**Consultation Response from KC,  
Ecology Unit**

**2023/92145 East Bierley Playing Fields, Hunsworth Lane, East Bierley, BD4 6PU**

**Date Responded: 18/08/2023**

3.5 Horizontal Spill: Iso Contour

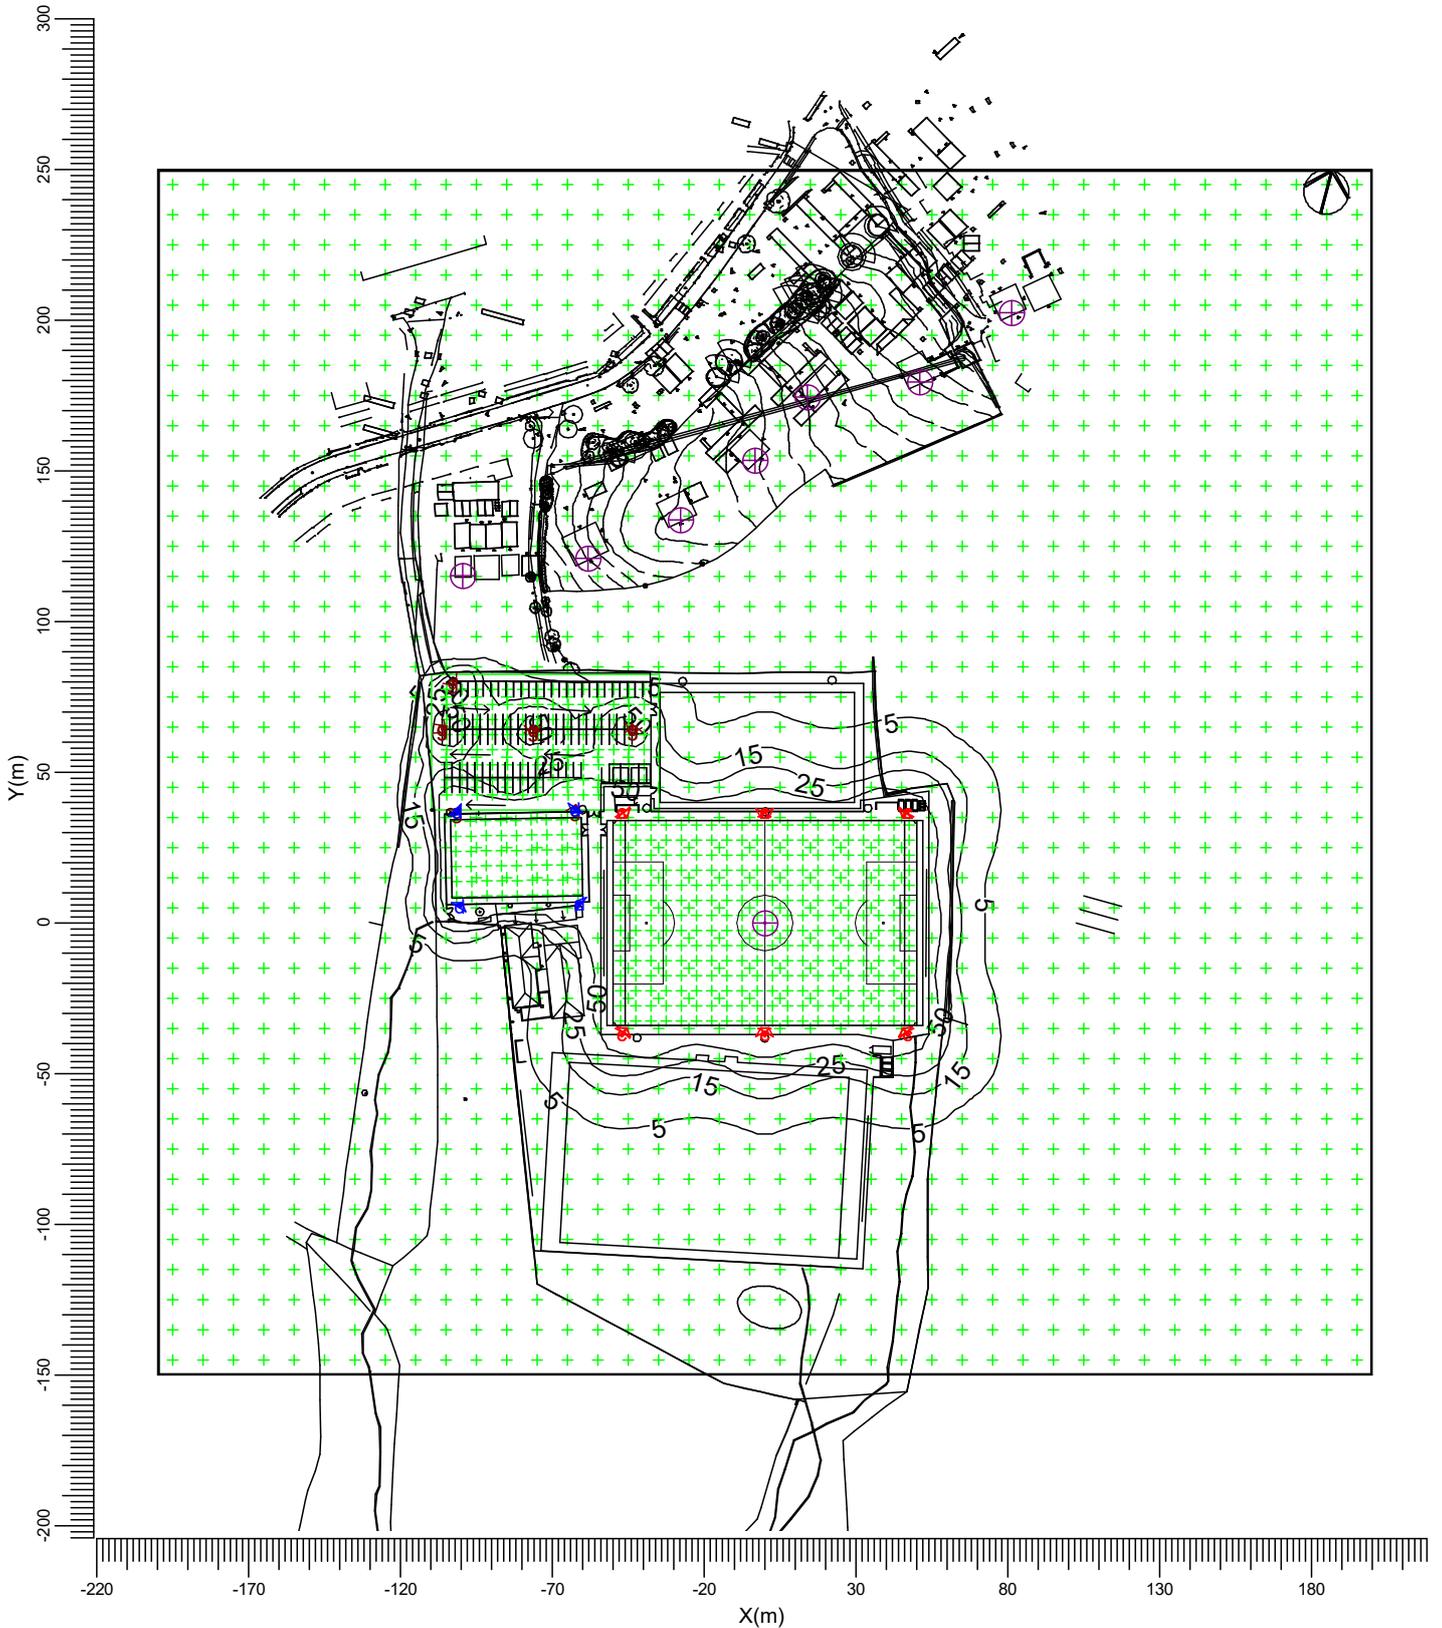
- Details on hours of use of all external lighting;
- The measures that would be taken to minimise or eliminate glare and stray light (beyond the boundaries of the site) arising from the use of the lighting;
- Details of methods of switching and controlling the lighting so that it is only operated at the permitted times and at times when it is required; and
- Details of measures to ensure the lighting's impacts upon habitats and biodiversity are minimised.

Given the above, the information submitted in support of condition 17 does not appropriately address the full requirements of the condition, particularly with its regard on details to minimise light spillage onto the surrounding habitat. This detail is required to safely ensure that the proposed lighting scheme can expensively state how impacts to biodiversity will be minimised throughout the operational phase of the development.
